WEST SUSSEX COUNTY COUNCIL CONSULTATION

TO:	Arun District Council FAO: Anita Gardner
FROM:	WSCC - Highways Authority
DATE:	3 September 2021
LOCATION:	Land South Of Littlehampton Road and East of Worthing Road Angmering BN12 6PN
SUBJECT:	A/169/21/PL Construction of a new access to serve existing agricultural use and proposed residential development. This site is in CIL Zone 5 and is Zero rated as other development.
DATE OF SITE VISIT:	n/a
RECOMMENDATION:	More Information
S106 CONTRIBUTION TOTAL:	n/a

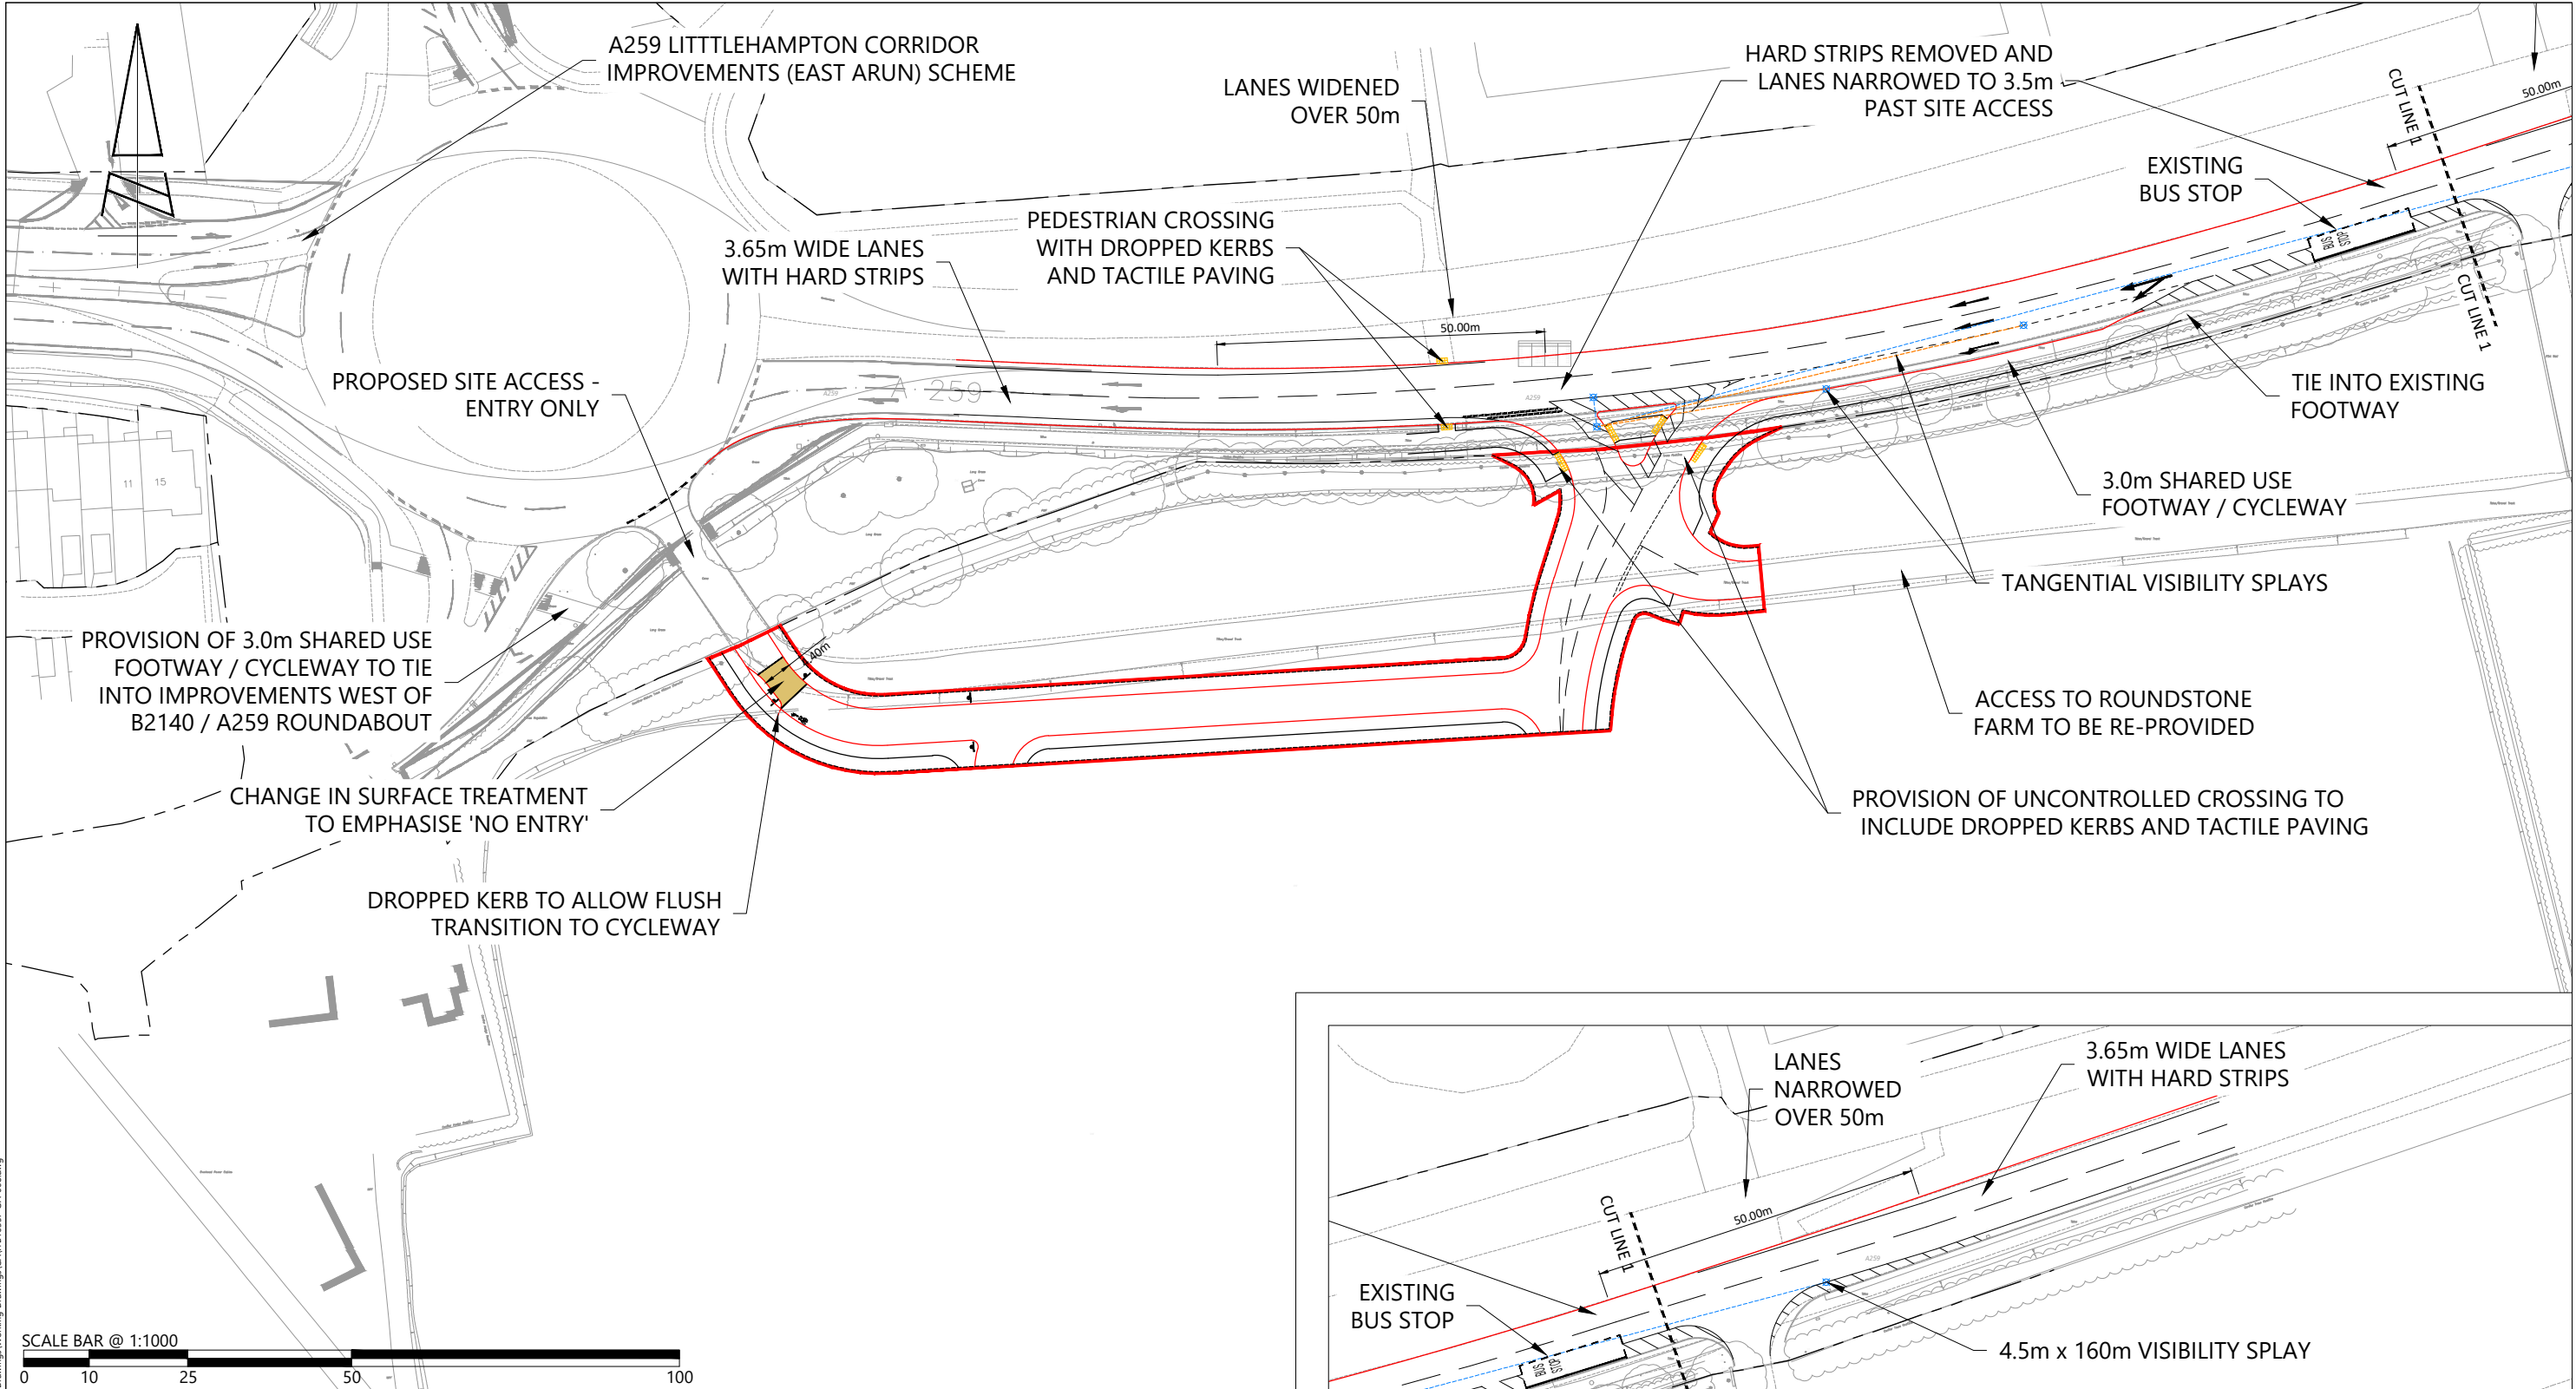
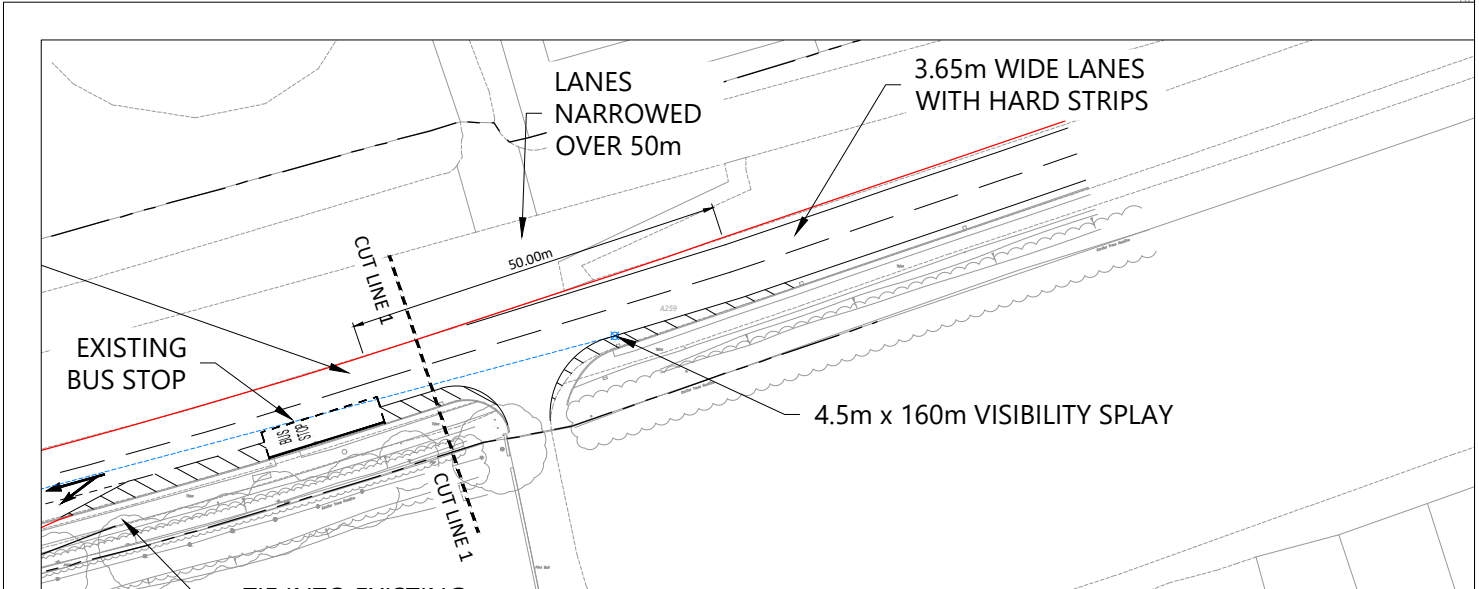
The access is proposed as a left in, left out with a diverge lane for vehicles entering the access on the westbound A259 dual carriageway. In this location the A259 is subject to a 50mph speed limit. Visibility splays of 4.5 by 160metres are proposed, which are adequate for the posted speed limit based on the standards included within the Design Manual for Roads and Bridges.

In submitting the current access details, the applicant has identified three departures from standard. The applicant has sought formal approval for these departures as part of the current application. There is however no design audit submitted that identifies the design standards applied by the applicant. Prior to WSCC Highways formally considering the DfS's, a design audit would be required. This should identify all standards used in the design of the proposed access.

It is also noted that no Stage One Road Safety Audit has been submitted. The applicant has confirmed that a Stage One RSA will be undertaken once the departures have been agreed. Planning permission must not be granted prior to the departures being agreed and a Stage One RSA being submitted in accordance with current WSCC Policy with all problems resolved to the satisfaction of WSCC Highways. A Stage One RSA must not be conditioned given the potential for this to identify unresolvable problems.

Although the DfS's have not been formally considered by WSCC Highways, one of the DfS's is recognised as relating to the retention of an existing bus stop on the A259. The general starting point with DfS's is that these are designed out where possible. In this instance, WSCC Highways would request that the bus stop to be removed in light of there being suitable alternate provision being available within reasonable walking distance. Given the bus stop is within the live nearside lane of a 50mph dual carriageway, there is an overall safety benefit for the stop being removed.

There is another access (a left in, left out) onto the westbound A259 located a short distance east of the proposed left in, left out. The current proposal is rendering this superfluous with there being a new internal access road connection leading to the various existing uses as indicated through notations on the submitted drawing. There is seemingly no reason for this access to be retained. The existing access onto the westbound A259 should consequently be permanently closed as part of the current proposal.
